National Infrastructure Planning
Temple Quay House
2 The Square
Bristol, BS1 6PN

Our Ref: EN010084

Application by Vattenfall Wind Power Limited for an Order Granting Development Consent for the Thanet Extension Offshore Wind Farm

Advice following issue of decision to accept the application for examination

### Land Plan (Onshore) - Sheet 0

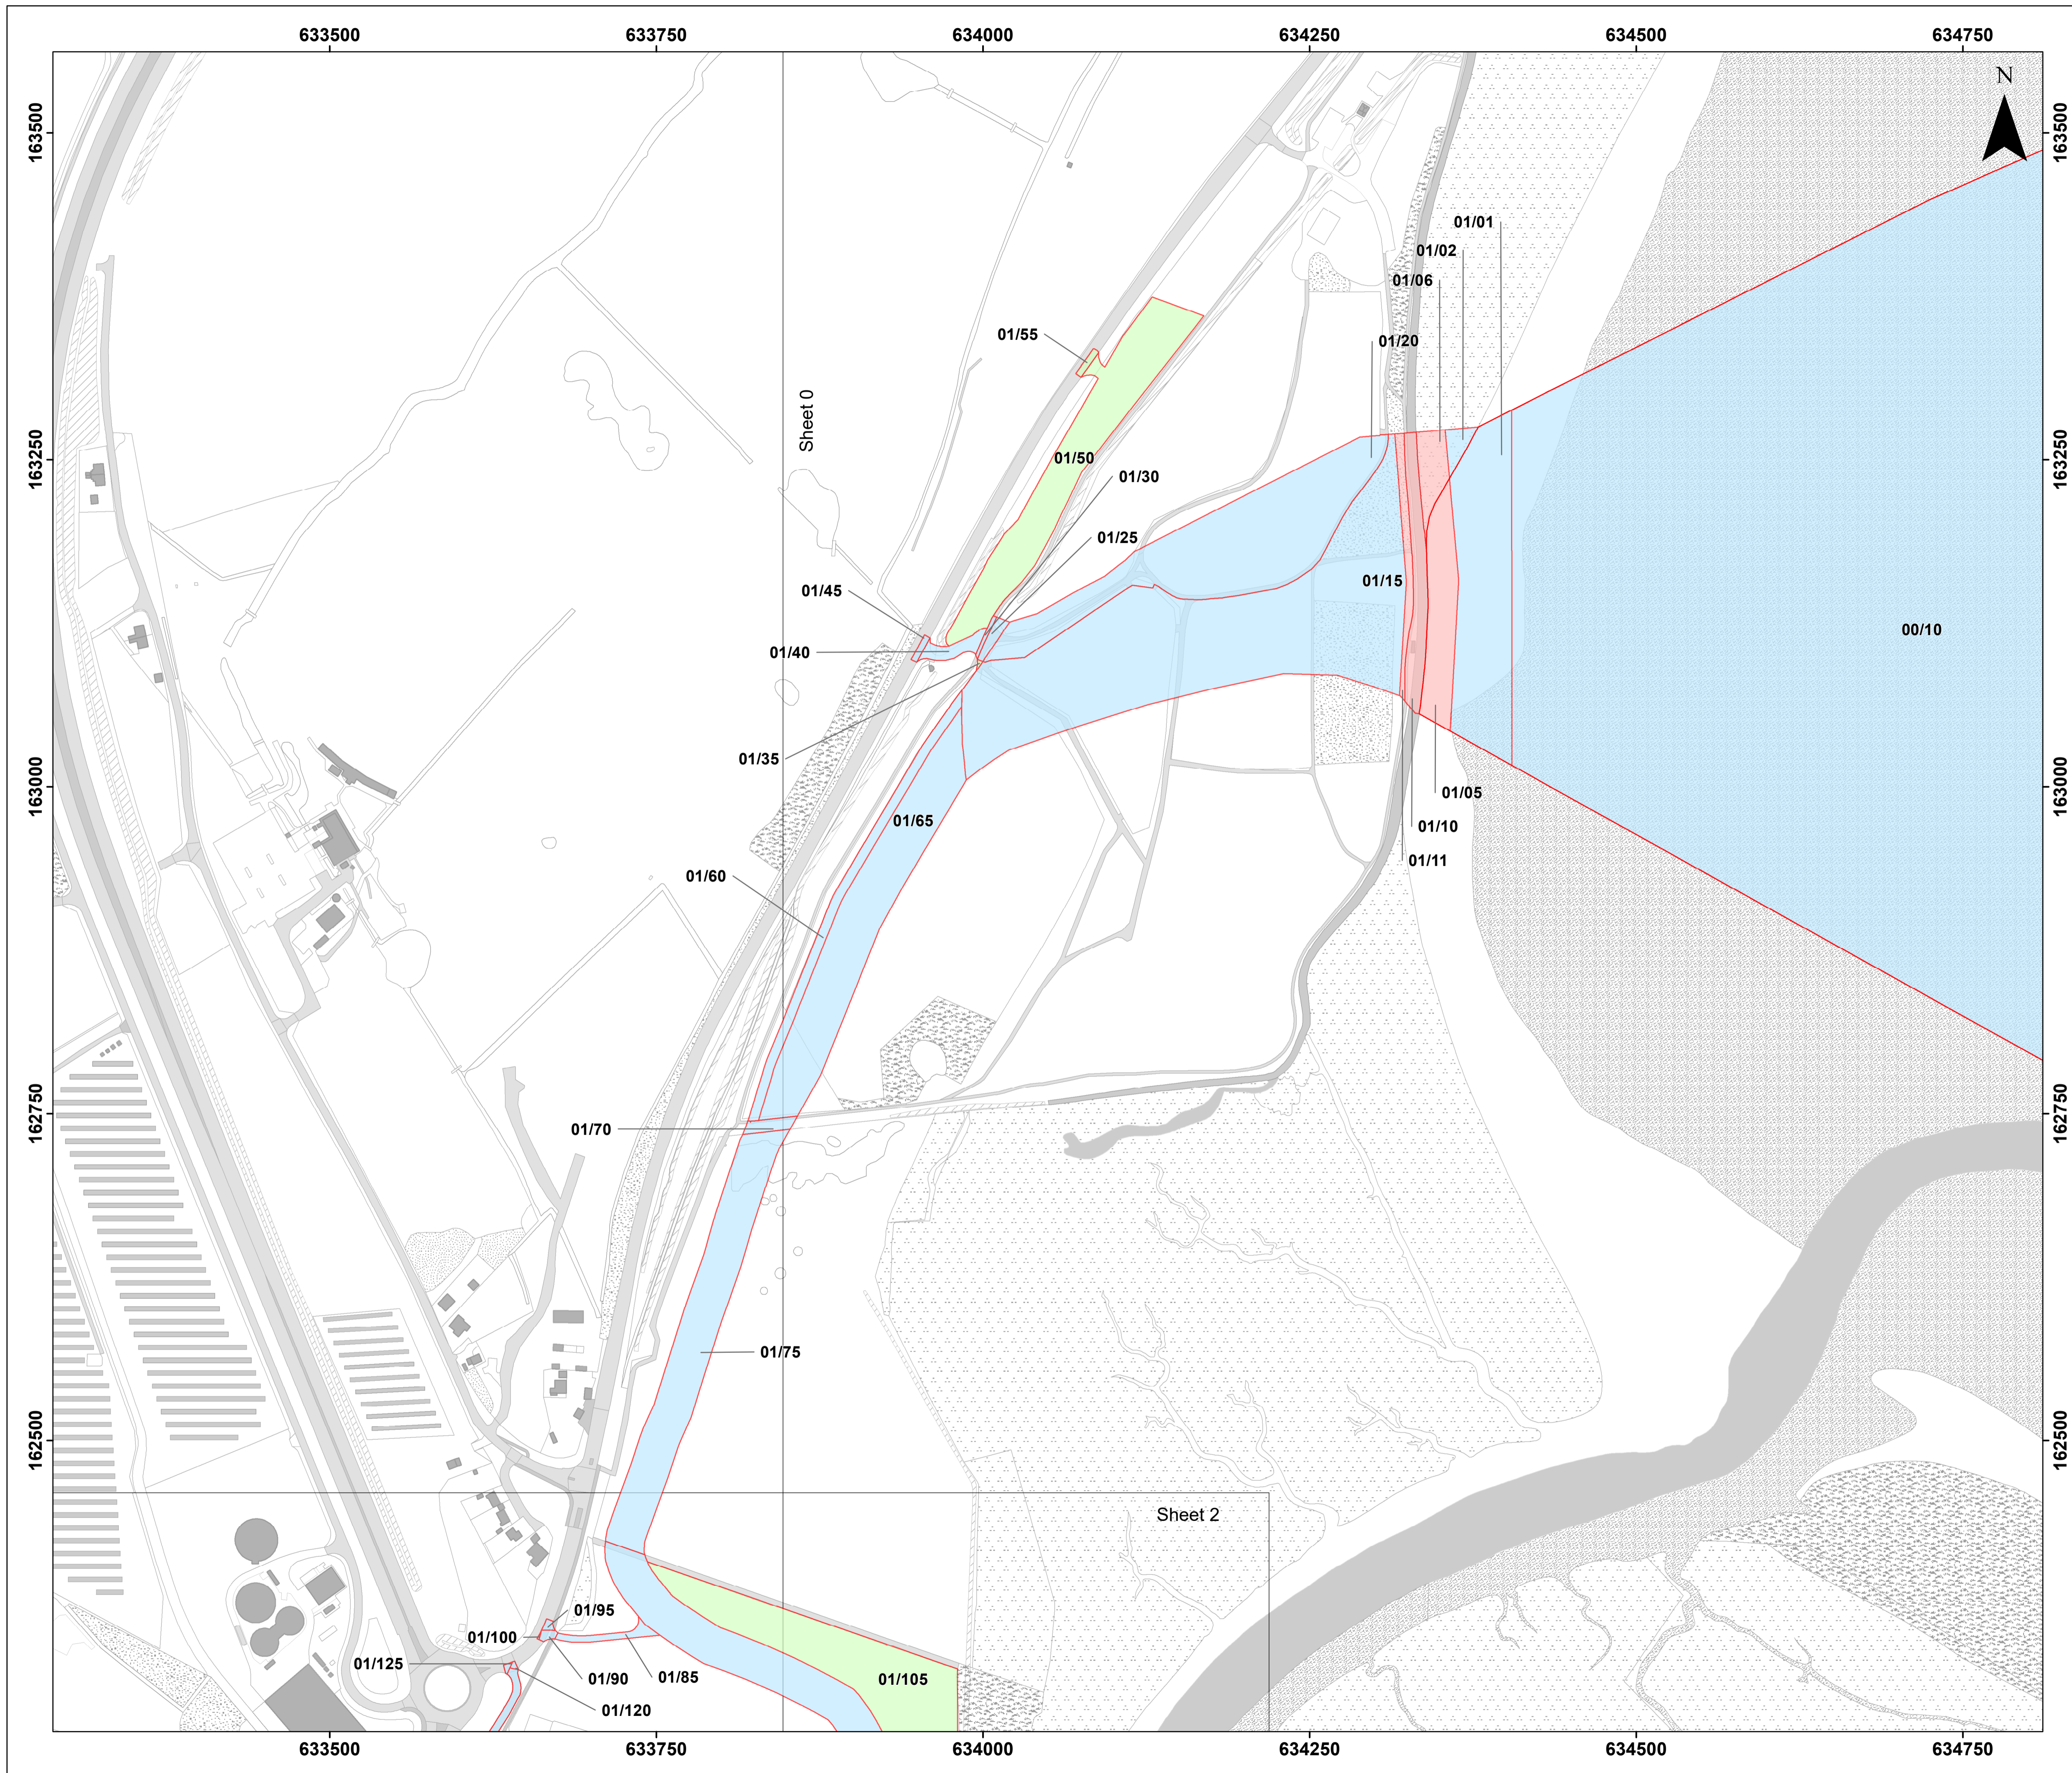
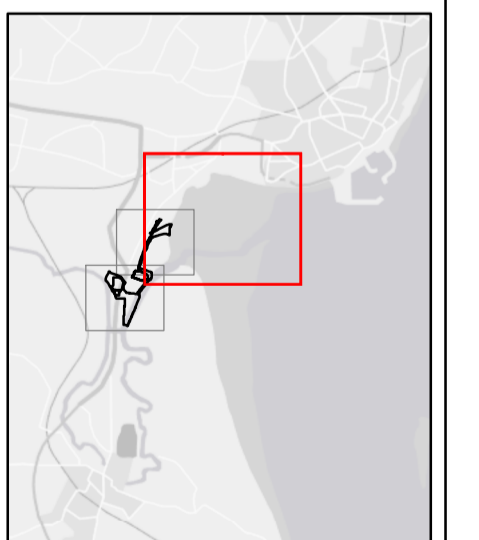
Please provide updated Land Plans that can be read which include:

- All relevant landmarks as described in Column 2 ('Description of Land') of the BoR e.g. Pegwell Bay Country Park, Sandwich Road, Ebbsfleet Roundabout and the A256 to be reflected on the relevant Sheets associated to the Land Plans.
- Insets to assist the reader.
- All plots on the individual sheets to be provided with the correct plot reference and colour code which is consistent with the other application documents.
